RFI

RFI #: 60
Date: 2/21/2012
Job: EB-02 Keller Springs Lofts
Phone: 877-777-5115

Subject: Confirmation that no expansion material is required

SHEET NUMBER
3.1C
BLDG PLAN 'C'

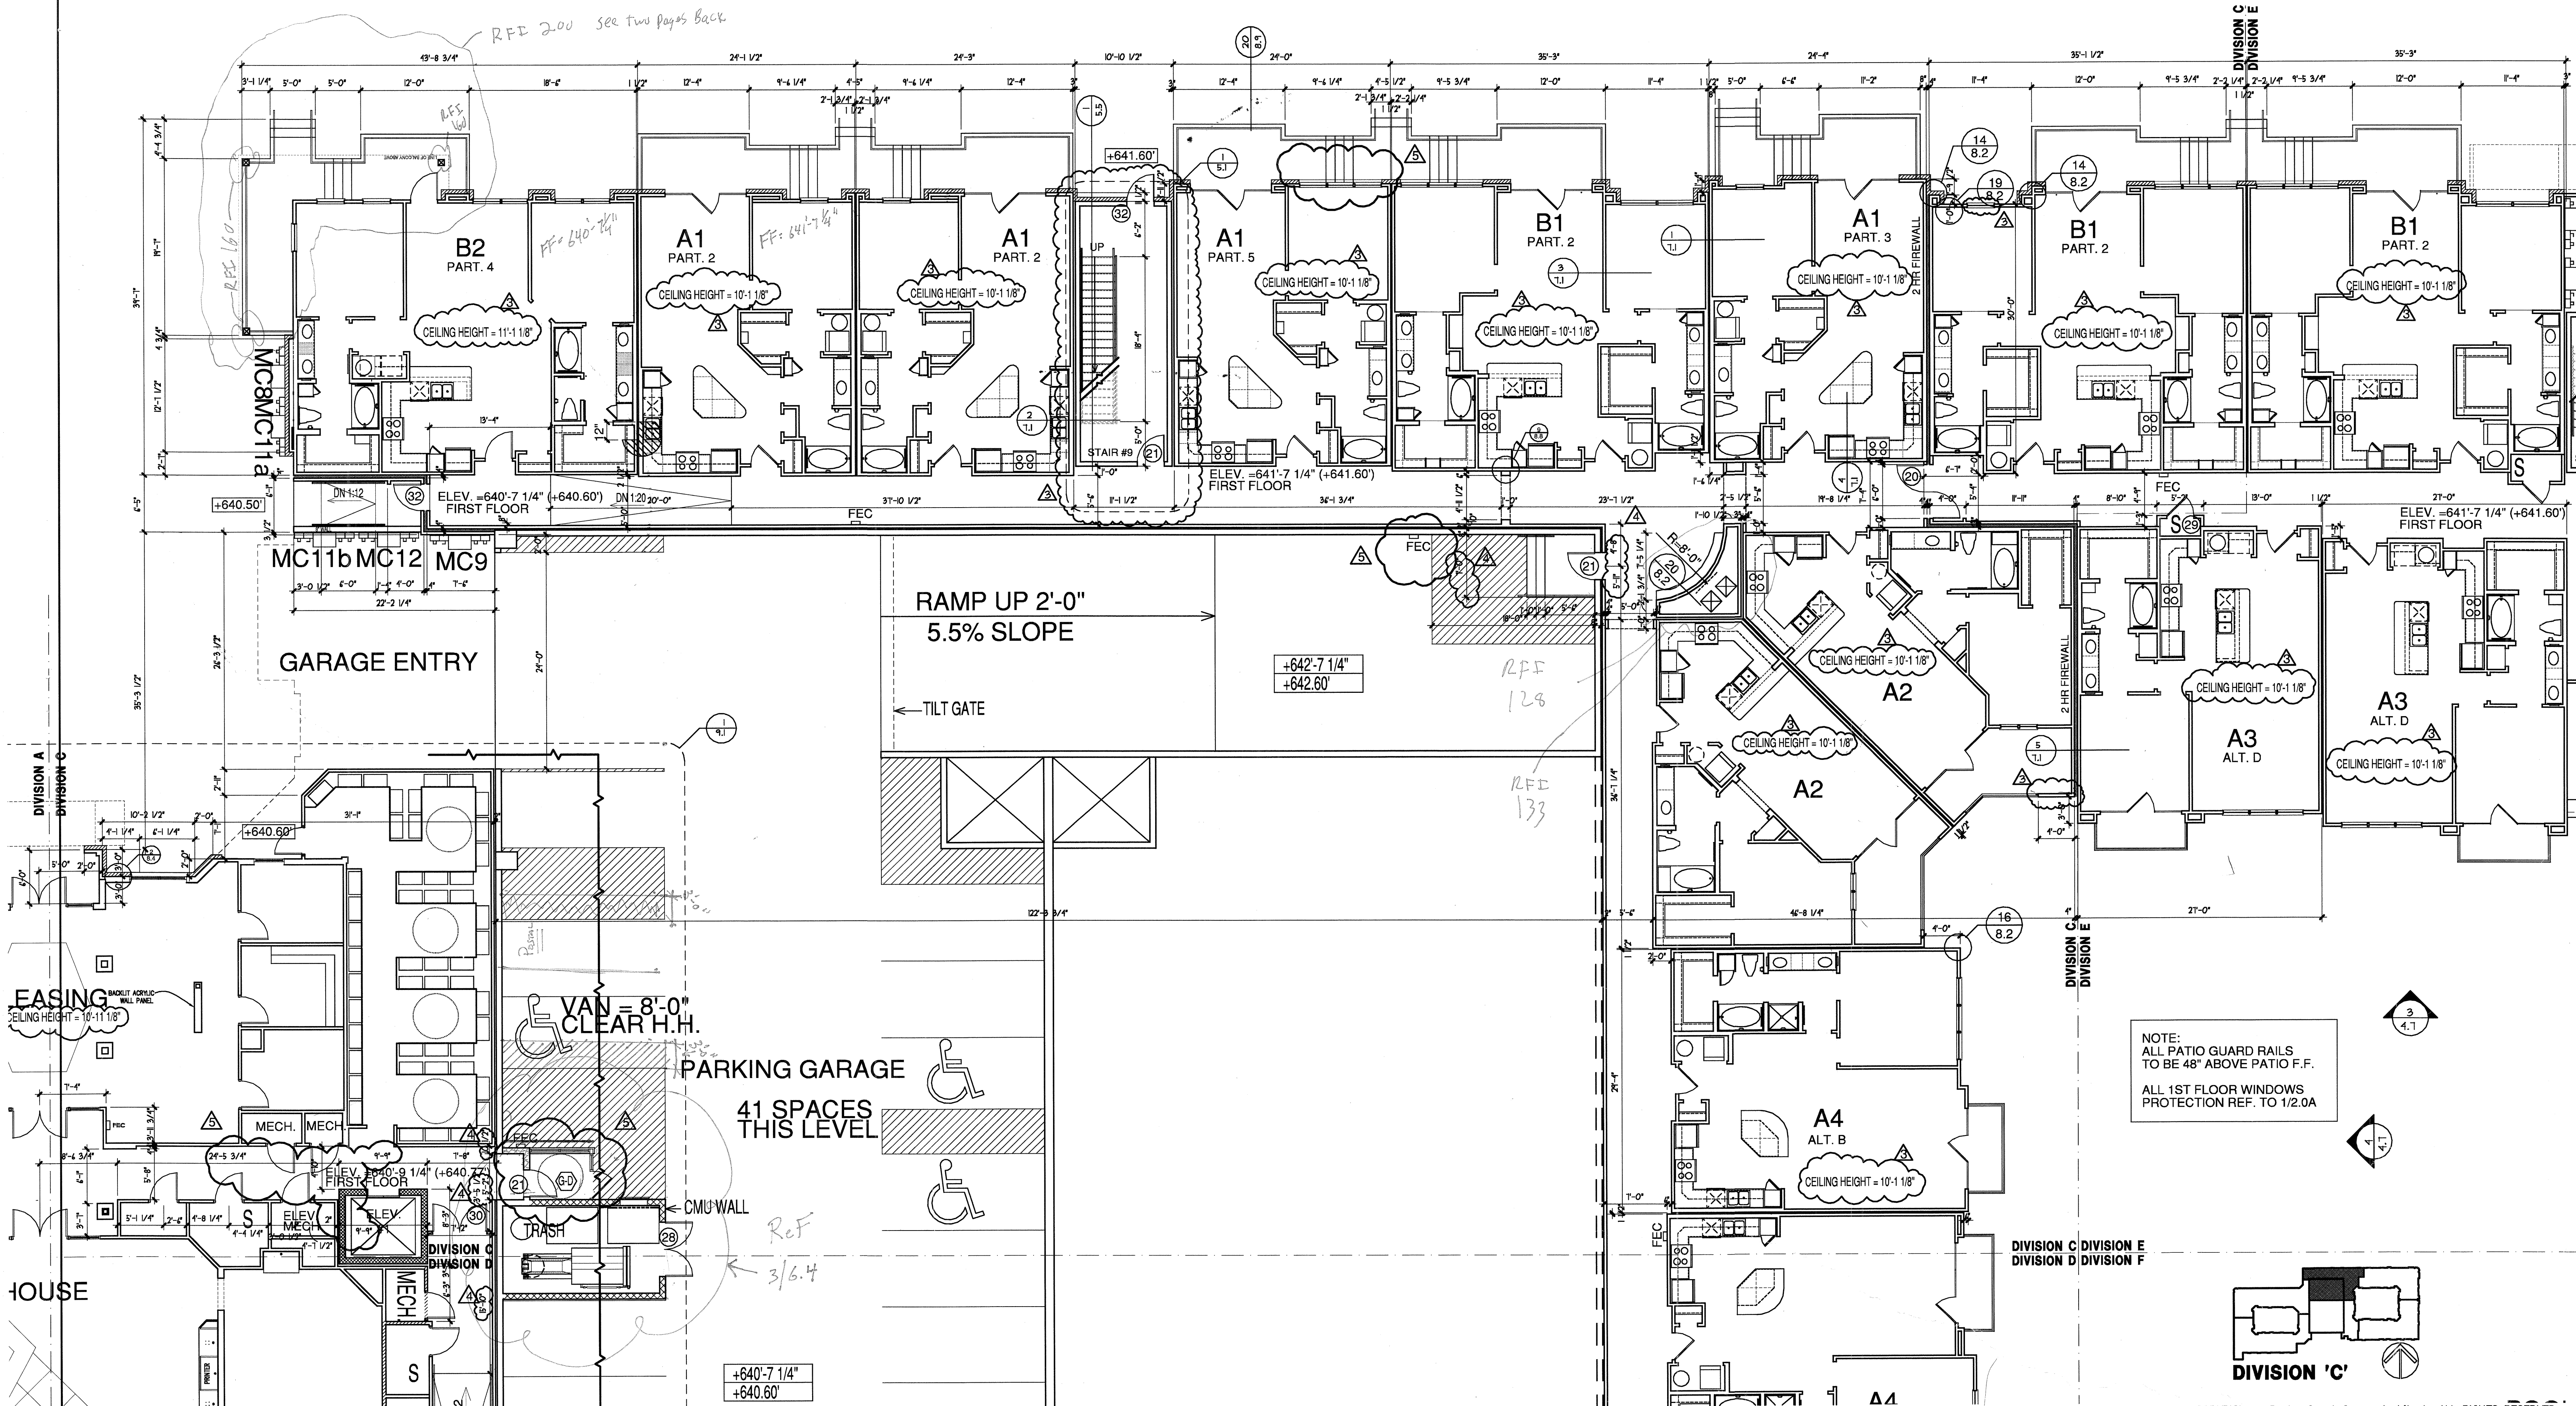
Request: Date Required: 1/10/2012
All Architectural plans show a 2" E.J. around the perimeter off the garage to the building see following, 3.1C- 3.1D, 1/6.1, 8/8.2, 1/8.7, 2/8.7, 4/8.7, 8/8.2, 15/8.5, 16/8.5, 20/8.4.

Response:
Answer from PPO please refer to revised structural drawings issued 1/4/12 for clarification.
